ATTACHMENT 13

ATTACHMENT 13 - WATKINSON APPERLEY PTY LTD RESPONSE TO DOP SUMMARY OF SUBMISSIONS

MAJOR PROJECT 06-0165 - RESIDENTIAL SUBDIVISION OF LOT 682 DP 568678, LOT 705 DP 613881 AND LOT 810 DP 247285, MANYANA DRIVE, MANYANA

Figure 4.11: Recommended fencing to protect coastal dune and vegetation. Source: gba Coastal, June 2010.

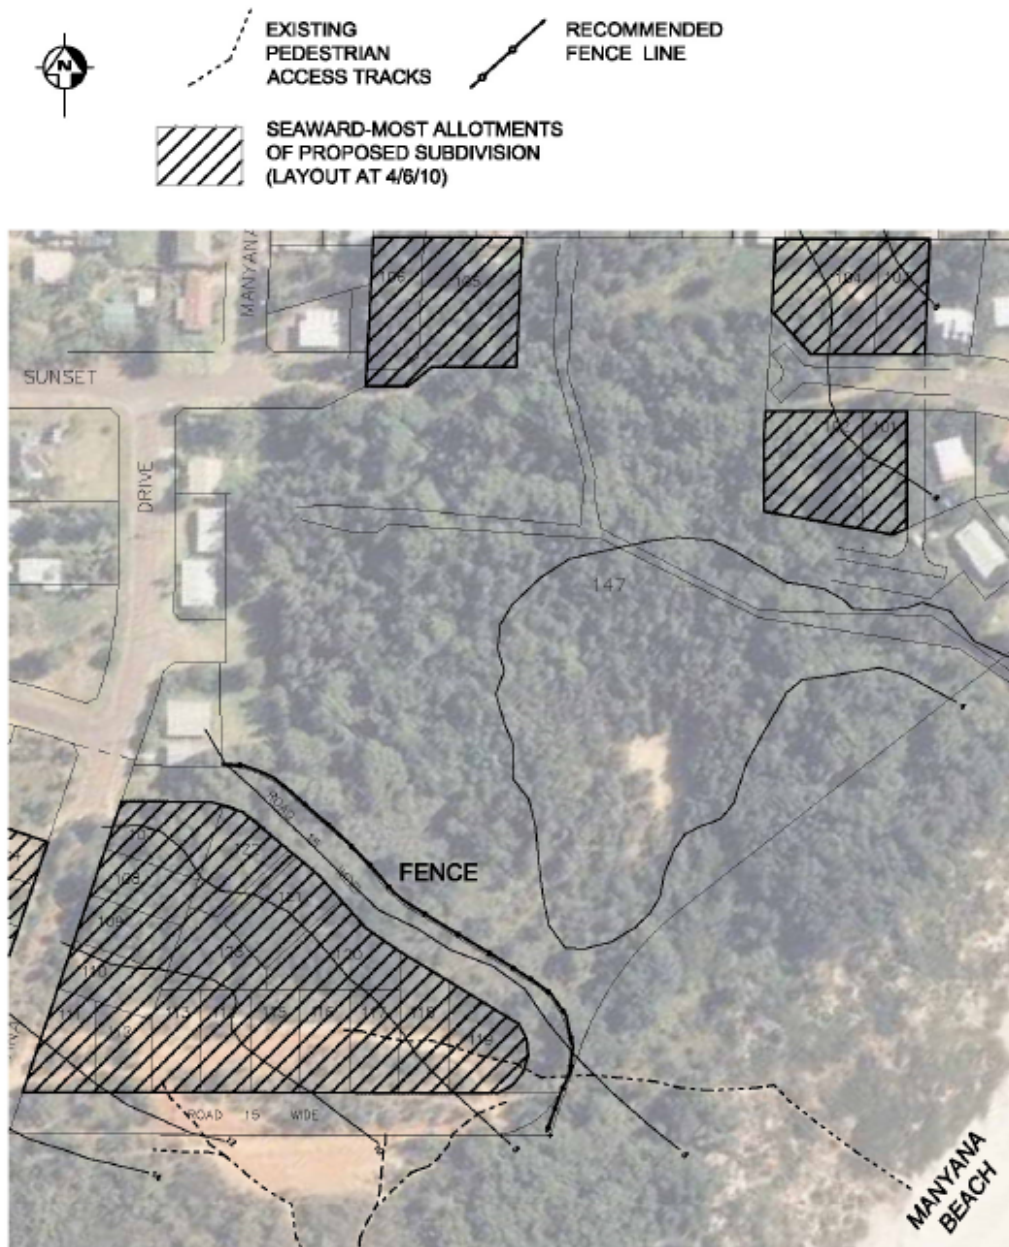
Issues	Response
	<p>level up to RL 6.7 (<i>up from 6.3 in the previous assessment</i>) at the primary coastal dune, and RL 5.7 (<i>up from 5.3 in the previous assessment</i>) at the flooded creek margin inside the entrance</p> <p>GBAC recommends that:</p> <ul style="list-style-type: none"> The residential allotments proposed at Lots 101, 102 and 104 have regard to the design RL 5.7 coastal inundation level. The residential allotments proposed on the western side of Lot 147 are sufficiently removed from the creek entrance and protected from direct wave action by the primary dune such as not to be impacted by wave run up inside the creek entrance. Consideration be given to incorporating a fence in to the proposal. This fence, of approximate total length 100 m, would be installed in the public reserve lot (<i>Lot 147</i>) generally to the north-east of the perimeter road. The proponent would install and maintain the fence for the first three years, after which maintenance for the fence would become the responsibility of SCC as managers of the public reserve (Figure 4.11). The fence could be of the conventional Bayco-type, with 100Ø treated pine poles at 5 m maximum spacing and three 4 mm wire strands (<i>galvanised and PVC coated</i>) equally separated and extending 1.2 m above the ground. Intermediate posts should penetrate 0.6 m into the ground, and end strainer posts 1.0 m into the ground.

TYPICAL ROAD CROSS SECTIONS

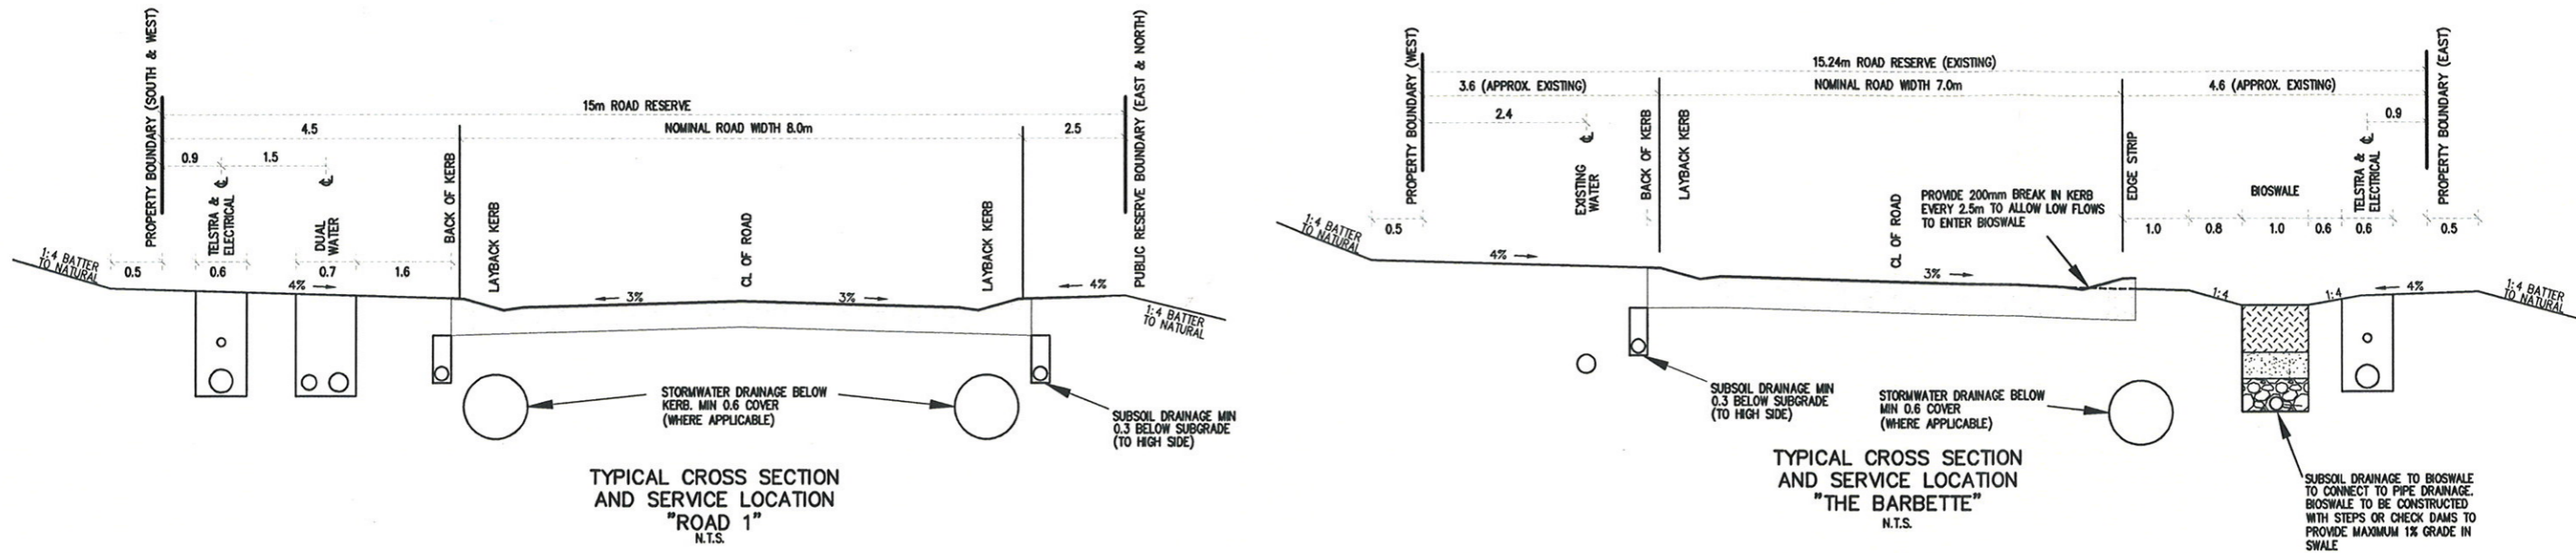
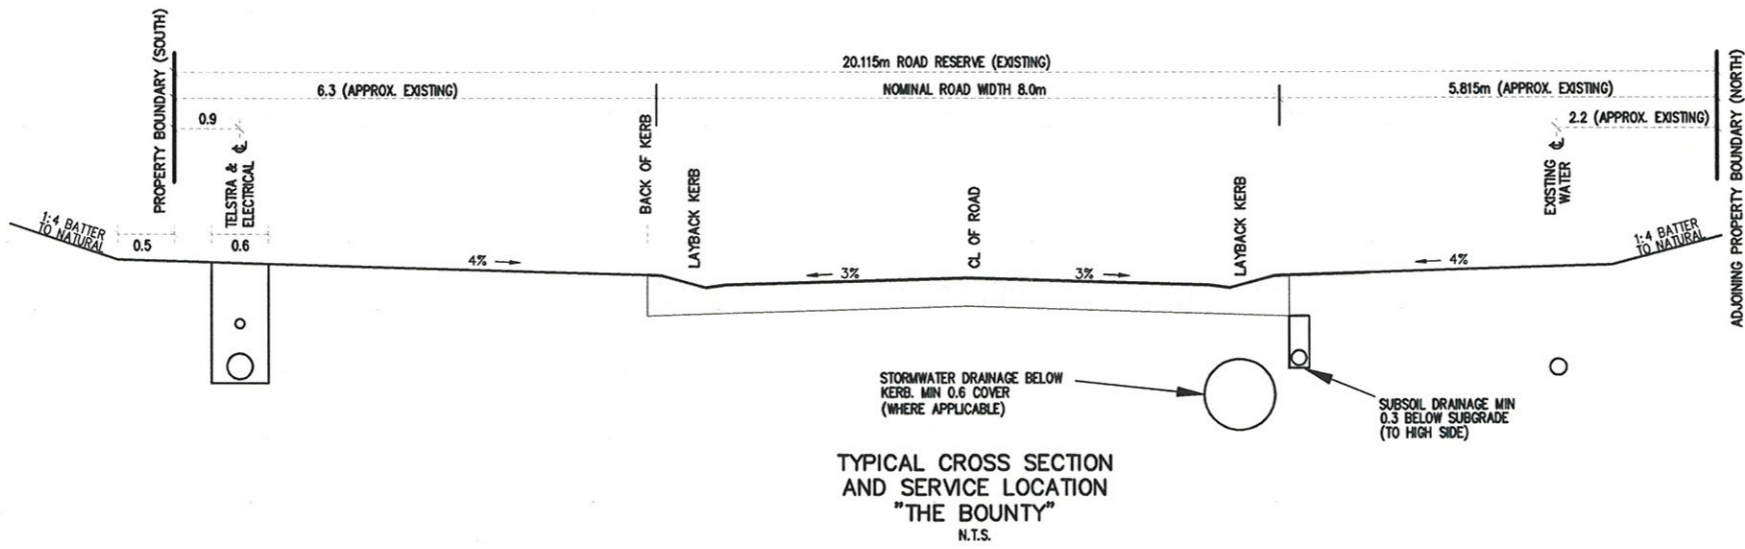
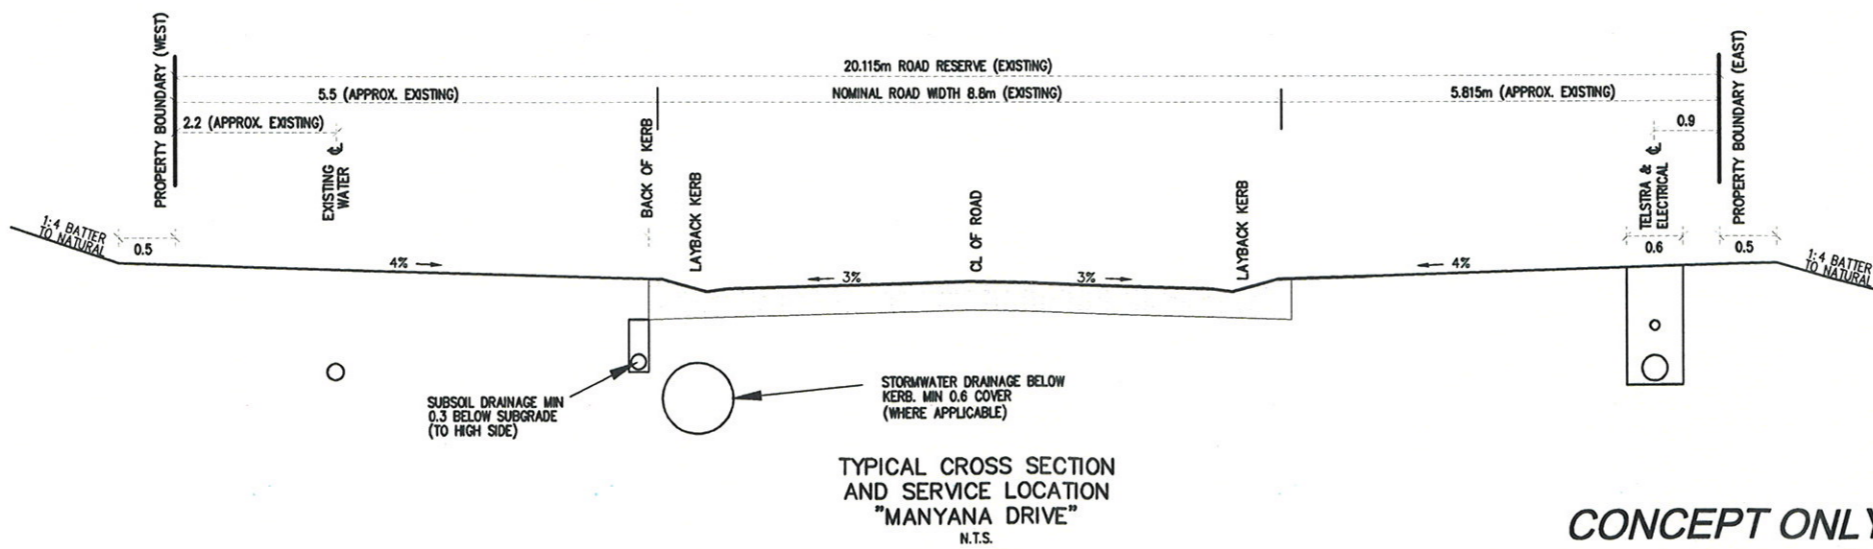
DCP classes Road (1) and (2) as "Access Roads" and the reserve width should be at least 16, with a minimum carriageway of 6m, except where the road is a perimeter road and the carriageway should be at least 8m.	The perimeter loop road (Road 1) will be located off Manyana Drive approximately 7m south of The Palisade and approximately 7m north of The Bounty. The perimeter loop road (Road 1) is proposed to have a 15 metre road reserve with a 4.5 metre verge on the western side and a 2.5 metre verge on the eastern side of the street with a 8 metre carriageway. It should be noted that the perimeter loop road will be a single load road and services will be only be required on the western side of the road. A typical cross-section is provided in Attachment 4. The side of the road with the reduced verge width will abut the public reserve lot. We are of the opinion that the 1m reduction in the road reserve width is justified in this situation.
